Current Zoning: CC (commercial center)  
Proposed Zoning: MUDD-O (mixed use development district, optional)

Approximately 18.4 acres located on the north and south side of Northlake Mall Drive, west of Interstate 77, and east of Northlake Centre Parkway.

The petition proposes a residential development with up to 603 multi-family dwelling units in two development areas at Northlake Mall.

# RZ-1.0

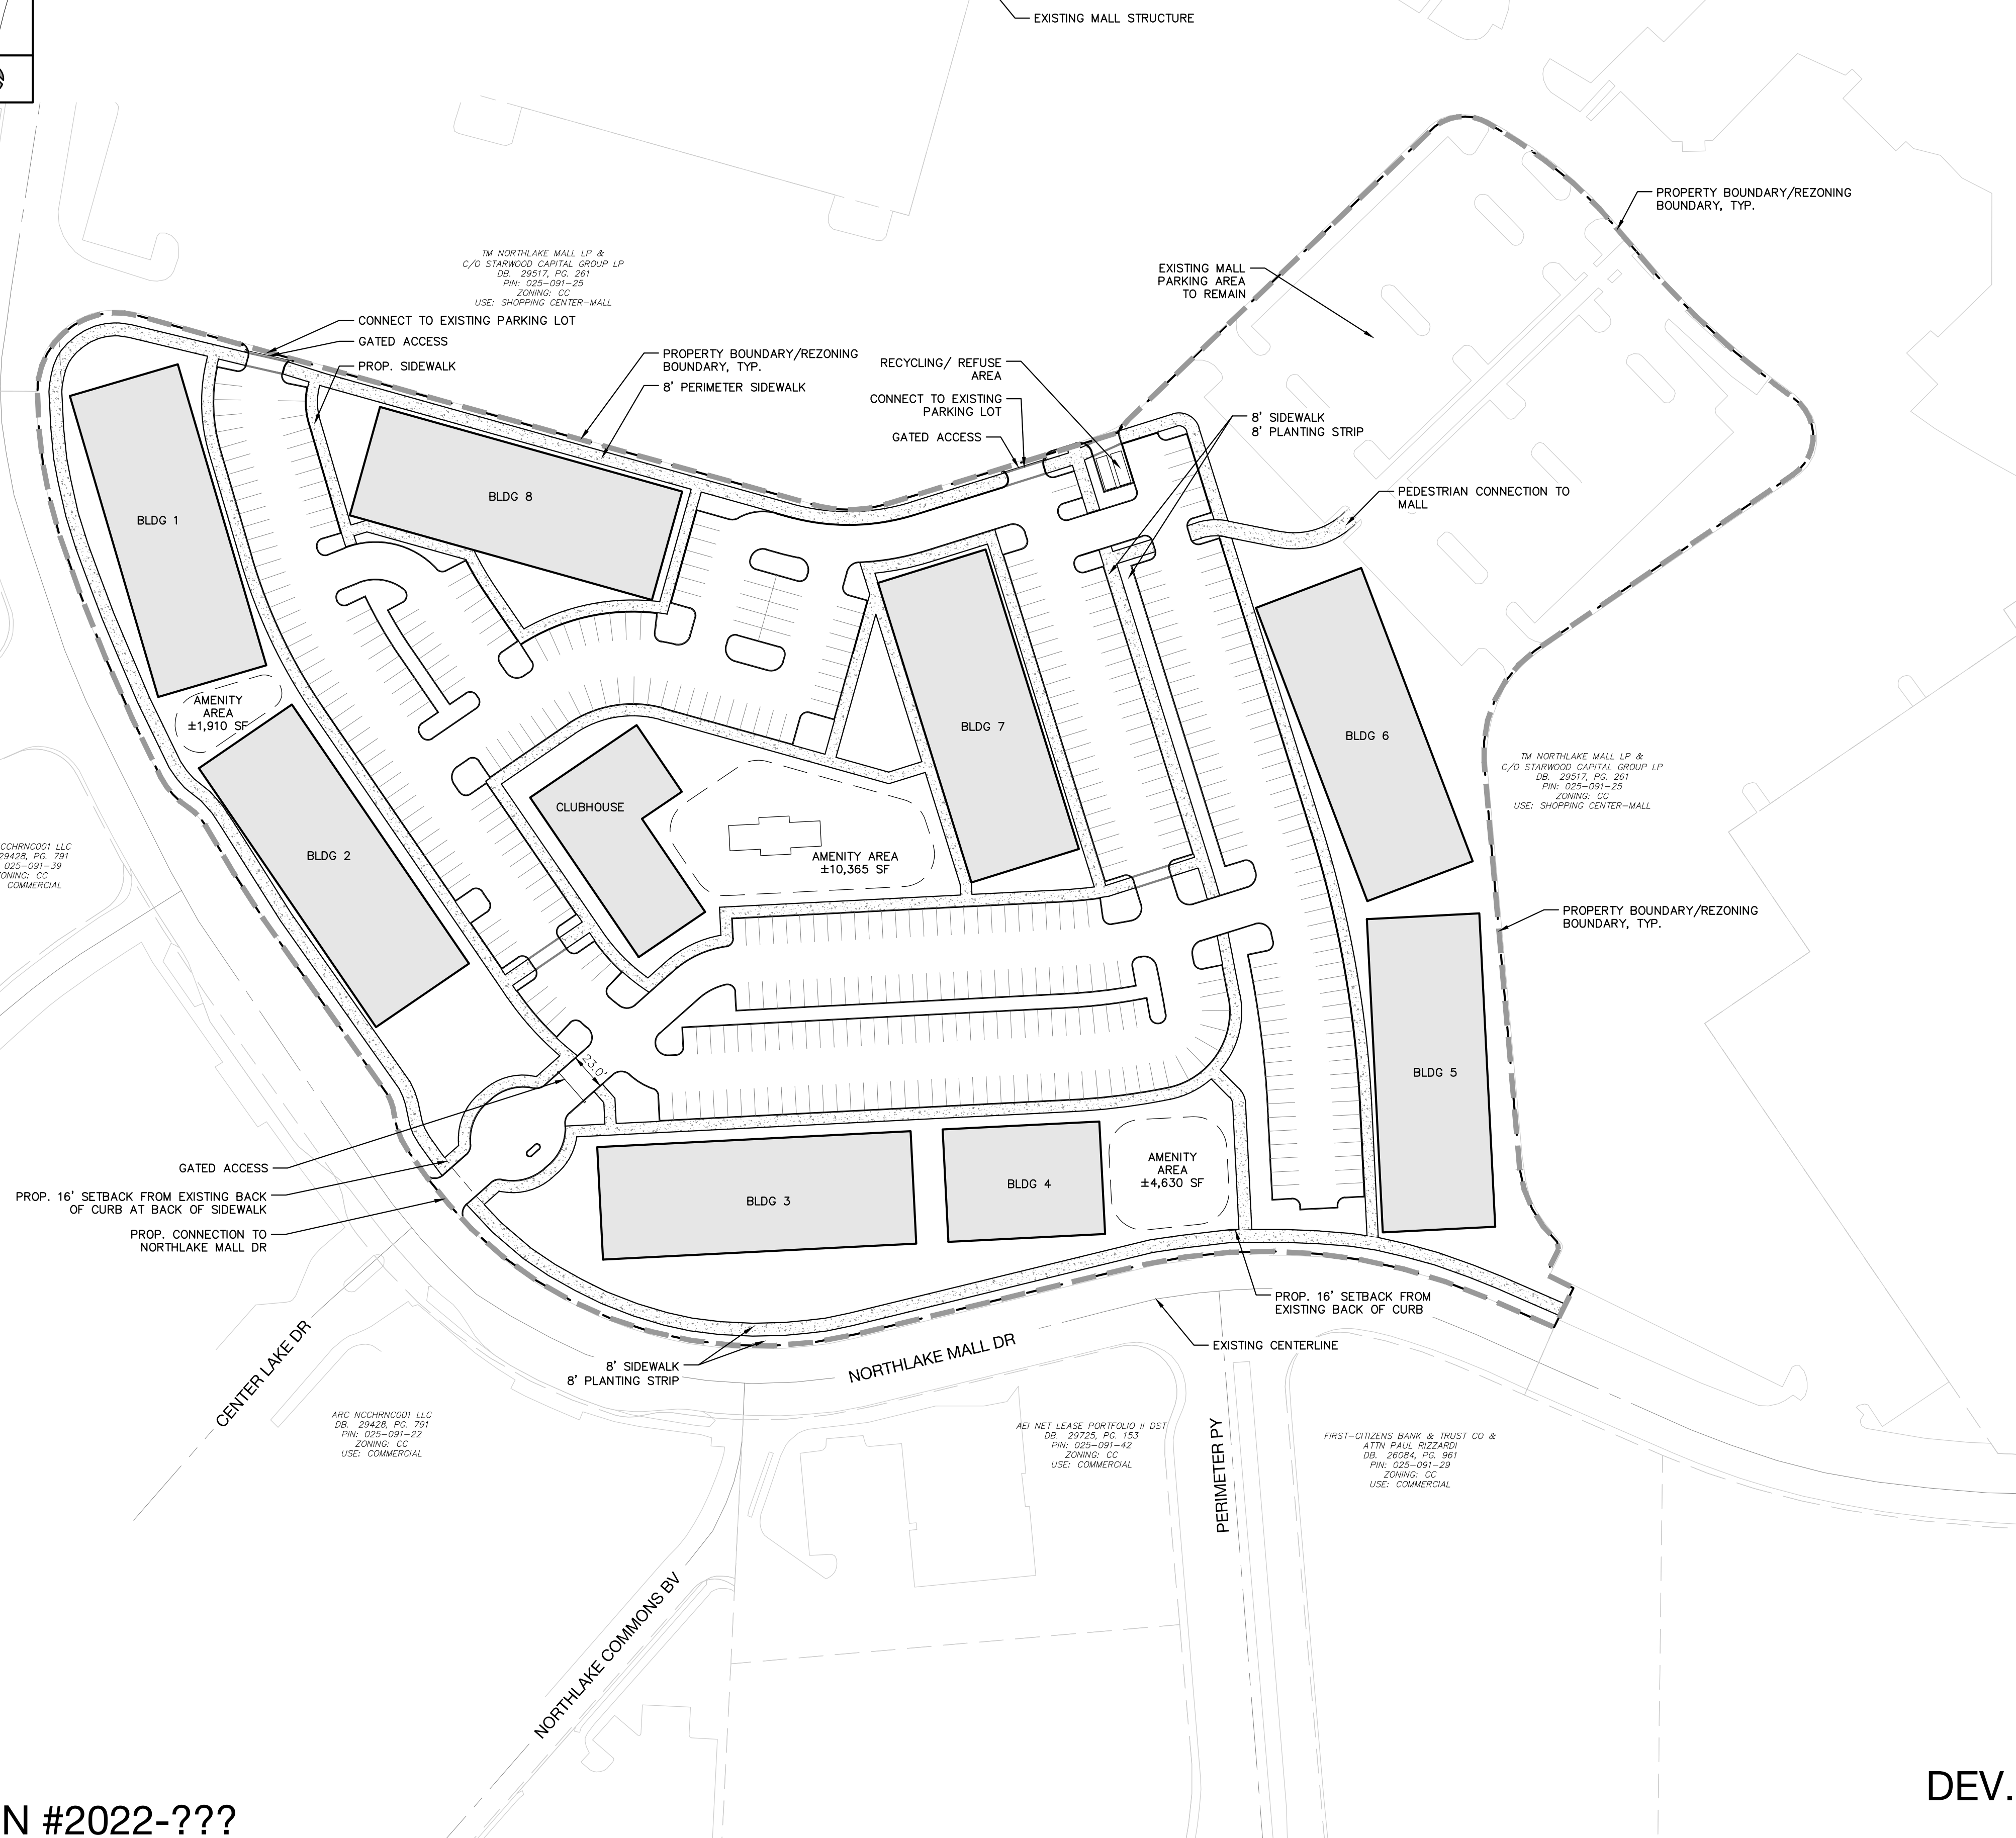
2. Remove the gated aspect to the multi-family development.
3. Extend Center Lake Drive, an existing commercial street with retail uses on either side and continue that street NE into the mall property. This street extension, paired with a similar building form where multi-family buildings face the street, will assist in building out a connected, walkable, and visually interesting regional activity center.
4. For Development Area B please use buildings to establish an edge that separates existing parking from proposed parking.
5. Clarify if a fence is proposed around the entirety of both development areas.
